**KIRKLEES METROPOLITAN COUNCIL
INVESTMENT & REGENERATION SERVICE**

DELEGATED DECISION TO DETERMINE PLANNING APPLICATIONS

Reference No: 2019/62/92391/E

Site Address: Greenways, Granny Lane, Lower Hopton, Mirfield,
WF14 8LA

FIRST FLOOR PLAN
1:50

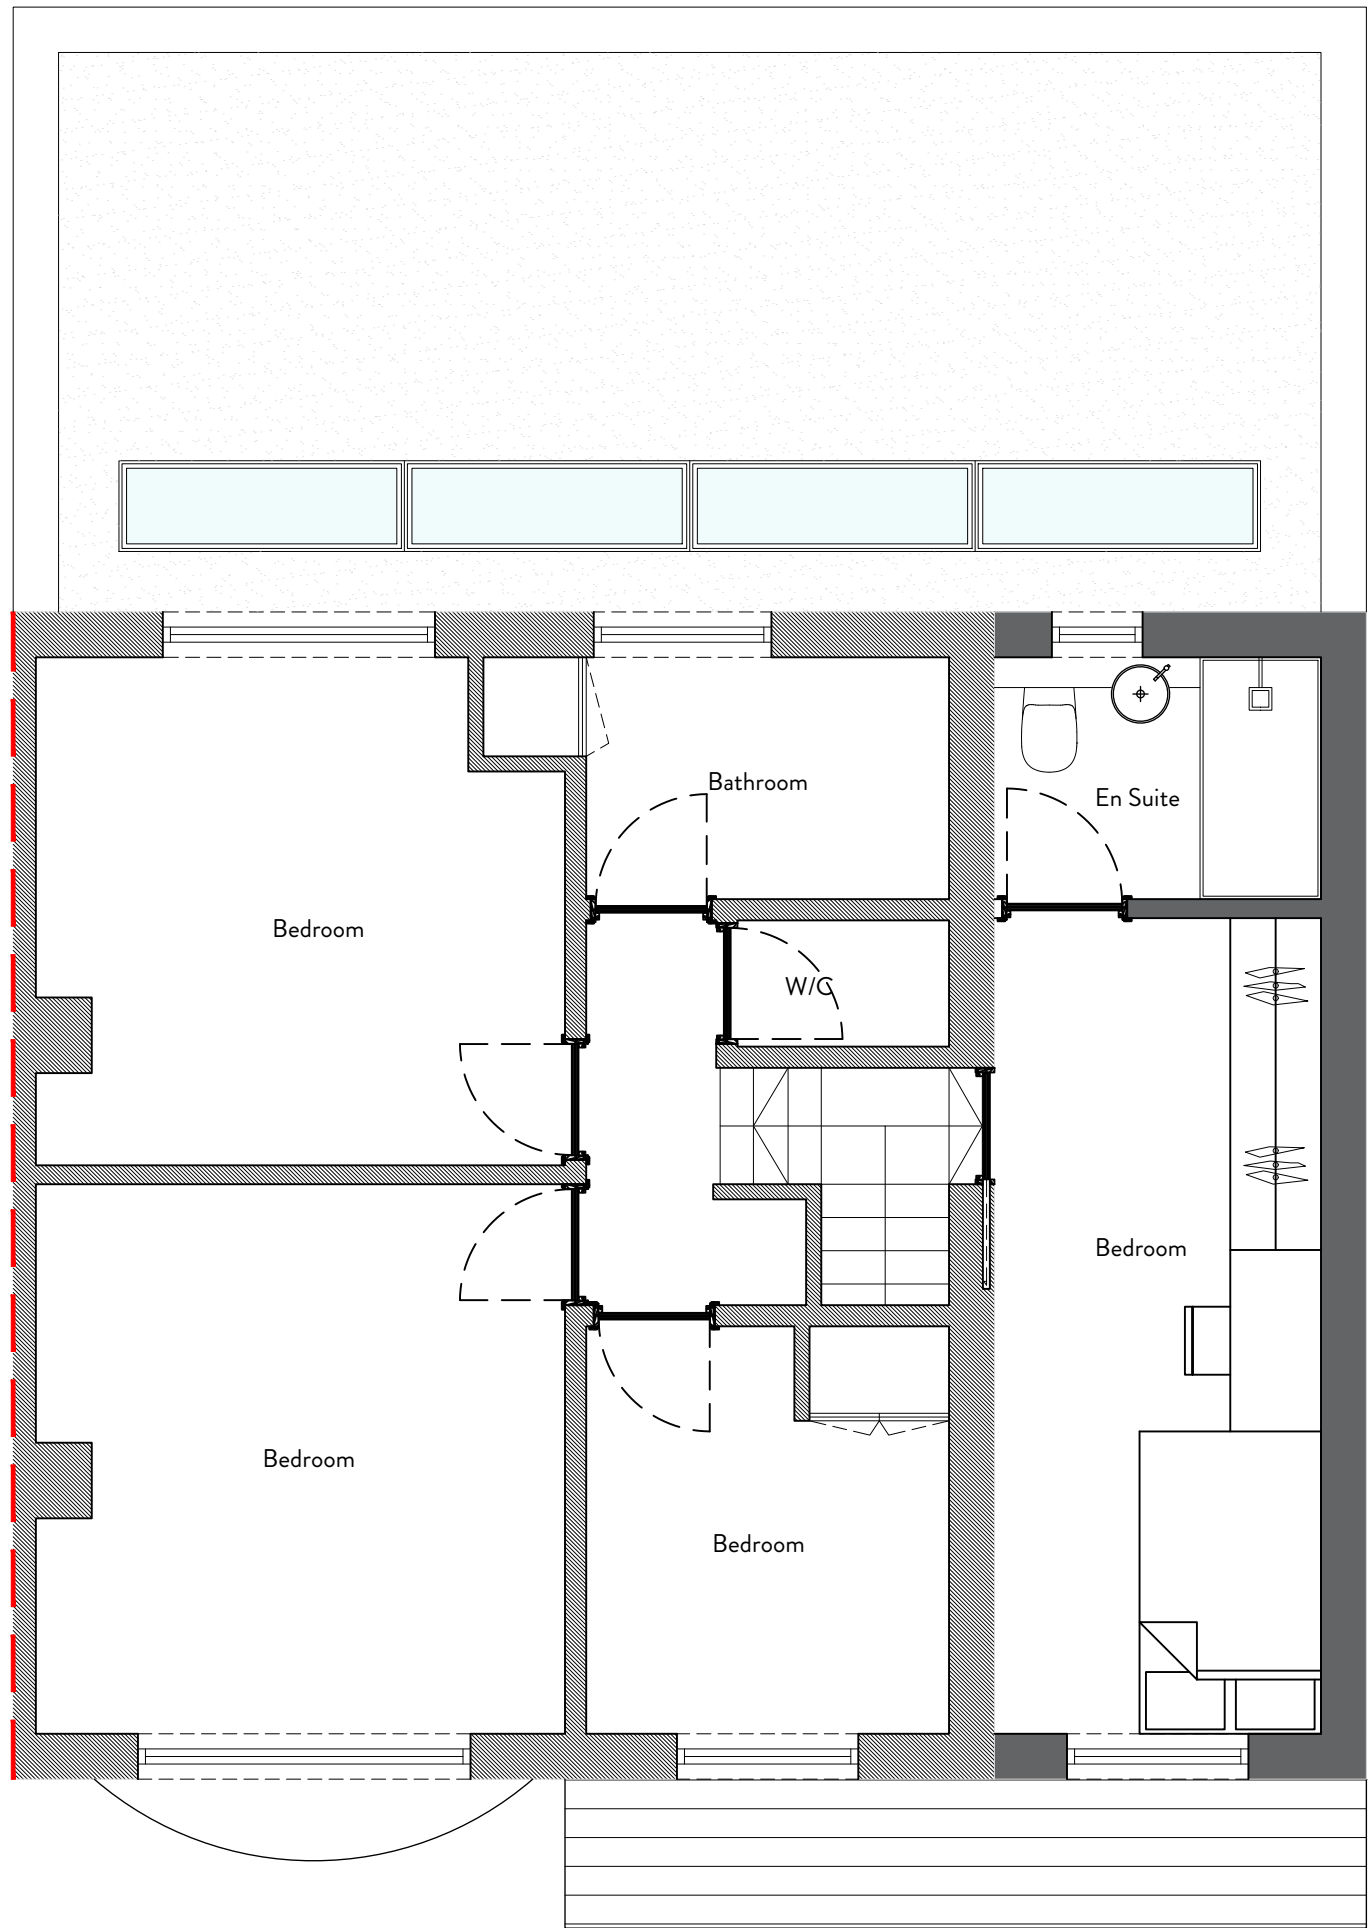
Concern was raised regarding the projection of the proposed rear extension along the boundaries shared with both the adjoining and adjacent properties. Amendments were also sought to the proposal to set the eaves and ridge height of the proposed two storey extension down from that of the host property to prevent the development from creating a terracing effect.

Amended plans were received from the agent reducing the projection of the rear extension from the proposed two storey extensions to 1.00 metre. Whilst the extension would still project 4.00 metres along the boundary shared with the adjoining property, given the height of the extension, its location to the west of the property and existing boundary treatment, this is considered, on balance, to be acceptable. The openings on the rear elevation have been altered to include a window, a door and bi-folding doors which would extend round to the western elevation of the extension where it would be set in from the boundary.

The amended plans show the eaves height of the extension set down from existing by 0.10 metres and the ridge height by 0.15 metres.
